TECHNICAL NOTE

Project Title: Land West of Pagham Road

Report Reference: JNY10700-04

West Sussex County Council – Highway Response

RPS Drawing/Figure Number JNY10700-01 Rev D

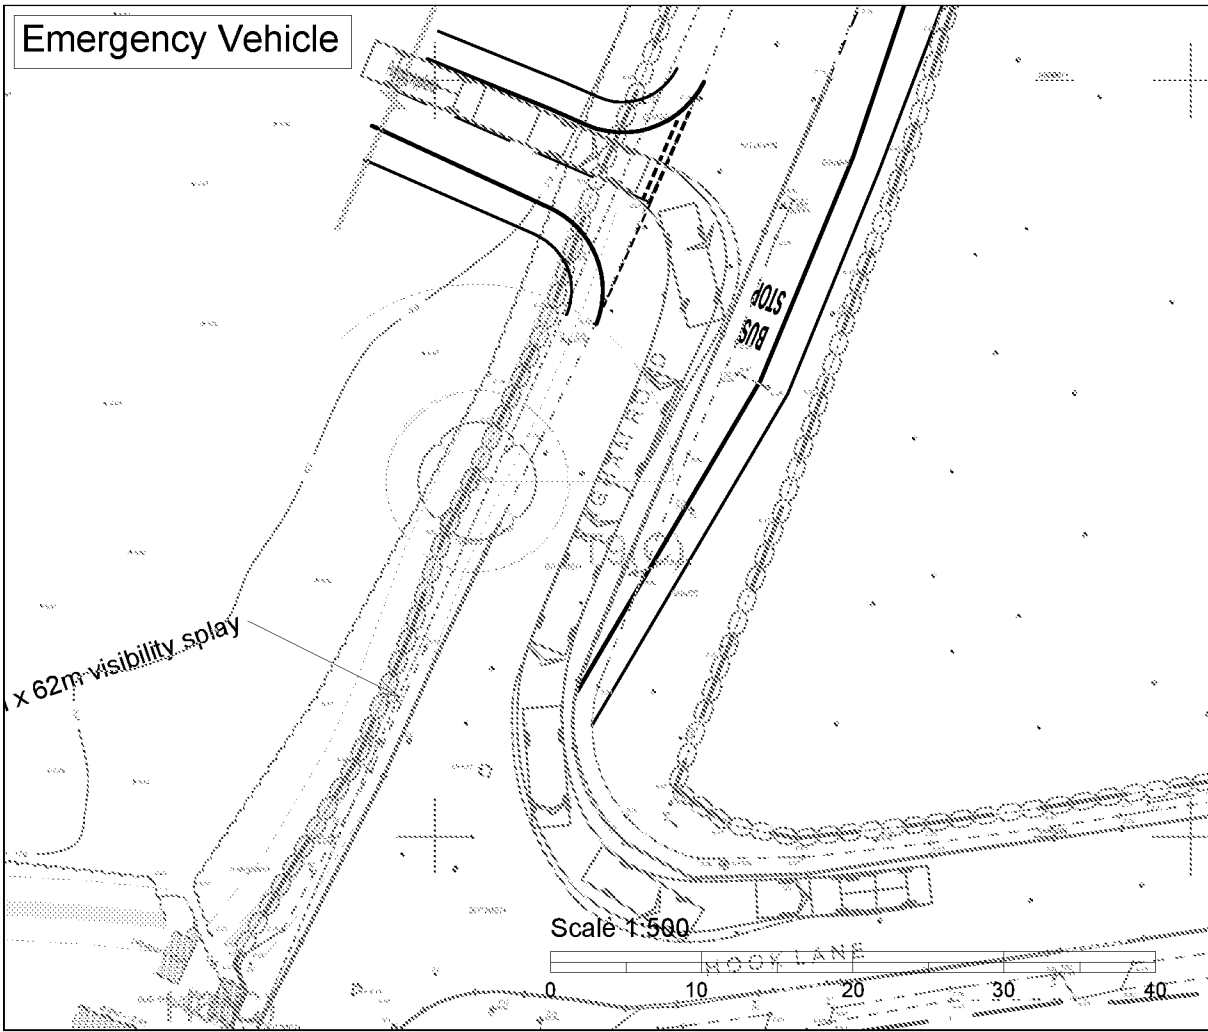
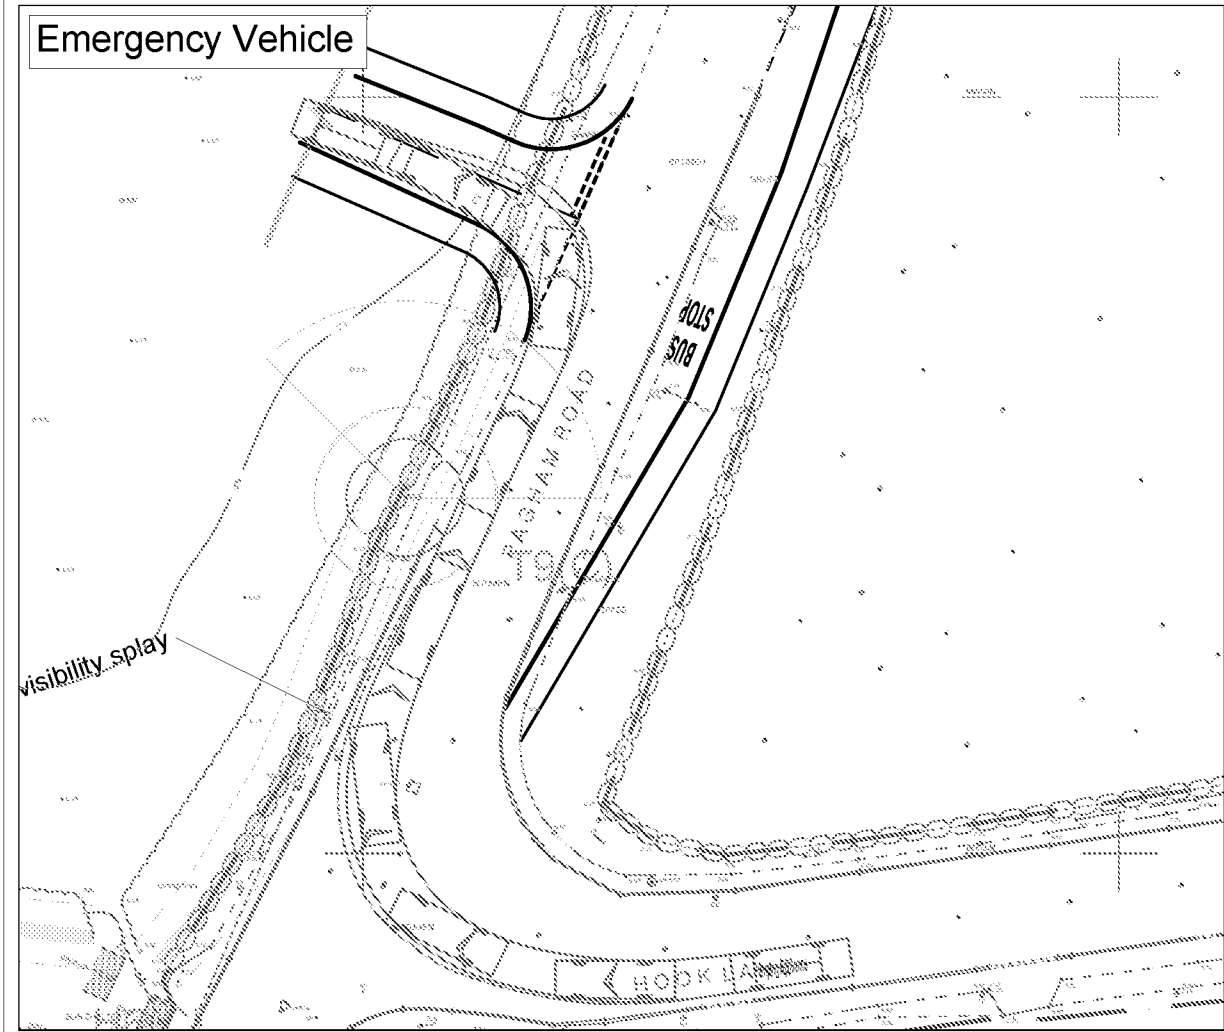
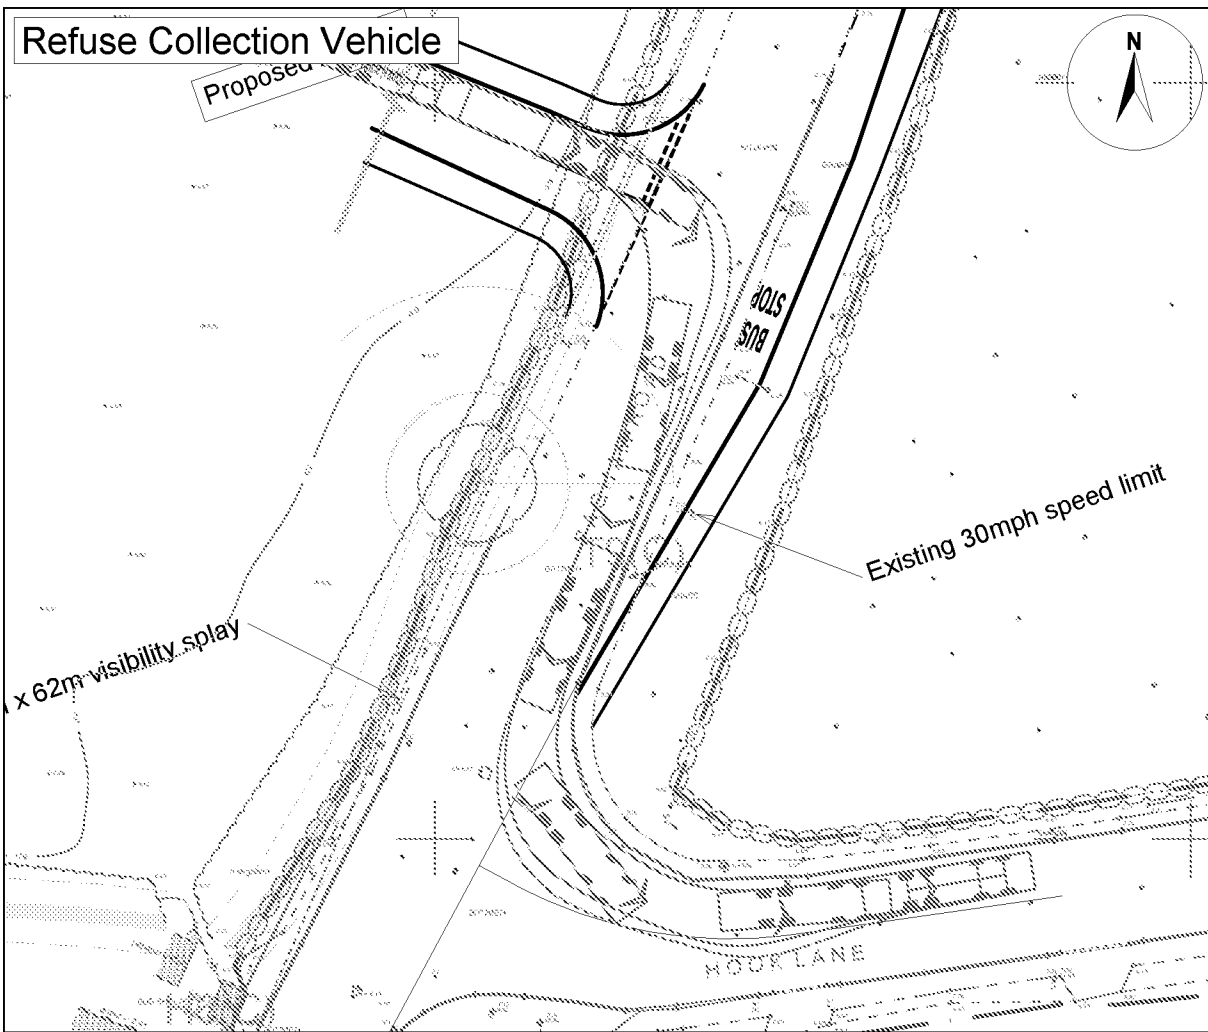
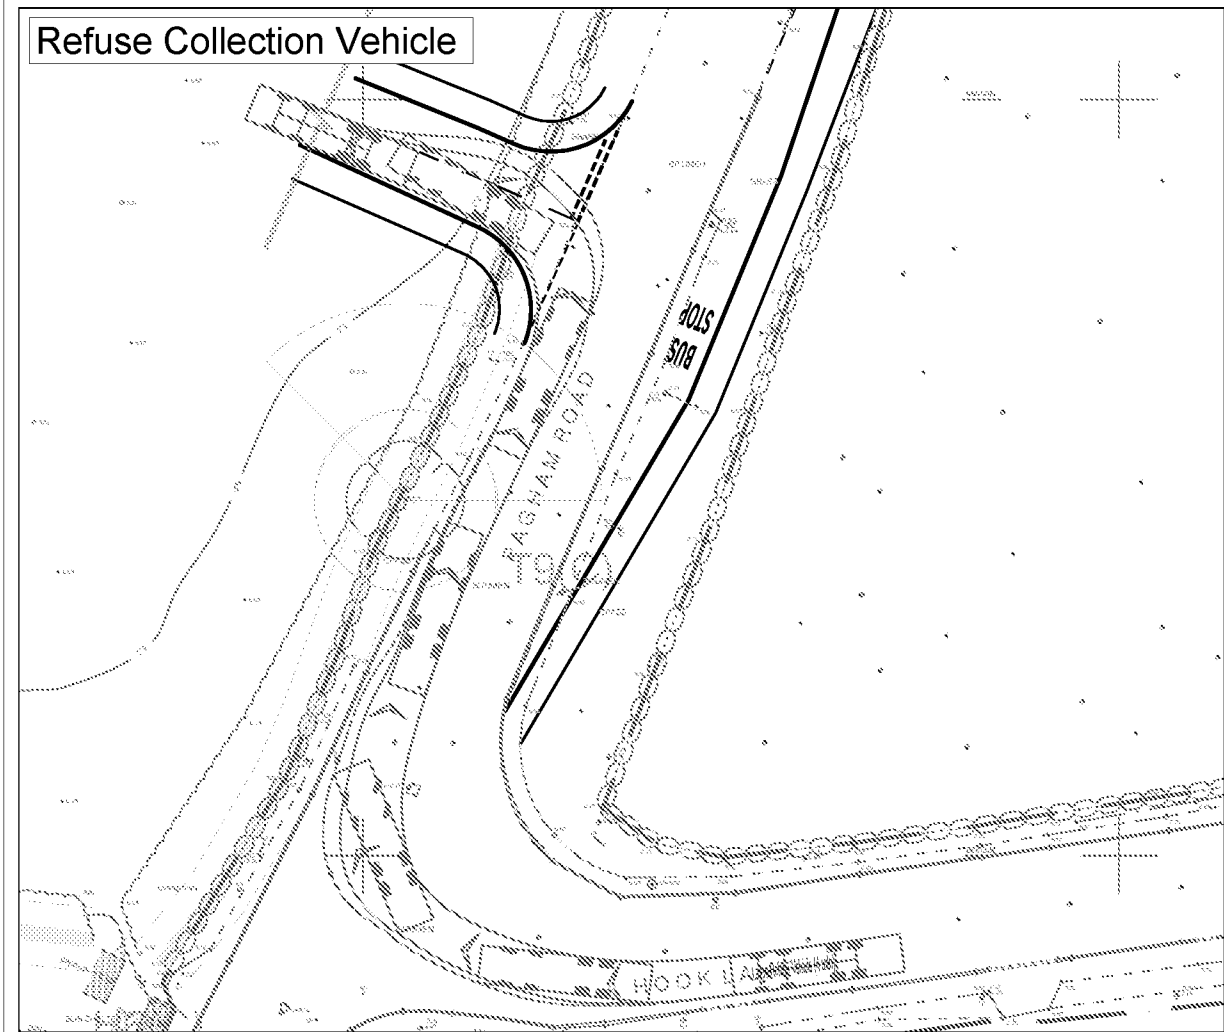
- 1.5 As requested by current WSCC policy, the access has been the subject of a Stage One RSA. The audit raises only a single problem relating to the need to provide a suitable pedestrian crossing point. The scheme designer has accepted the problem, and this is to be resolved as part of the detailed design. The designer should note that they are required to record their comments as per the format within GG119 (the overarching standard for road safety audits) and submit to WSCC Highways to allow further comments and agreed actions to be added. The road safety response form should be submitted and agreed directly with WSCC Highways.

PROBLEM	1
Location	Proposed development access (Drwg No. JNY10700-01 Rev D)
Summary	Lack of pedestrian provision may result in pedestrian to vehicle type collisions.
The drawing indicates that a new development access junction is proposed on the western side of Pagham Road. Dropped kerbs and tactile paving are not shown on either the northern or southern side of the junction. This may increase the risk of pedestrian trip hazards and/or vehicle to pedestrian type collisions	
RECOMMENDATION	
The Audit Team recommend that appropriate dropped kerbs and tactile paving are provided.

- 1.6 The format of the Stage 1 Road Safety Audit Designer's Response has been amended in accordance with GG119 and is provided at **Appendix 2**.
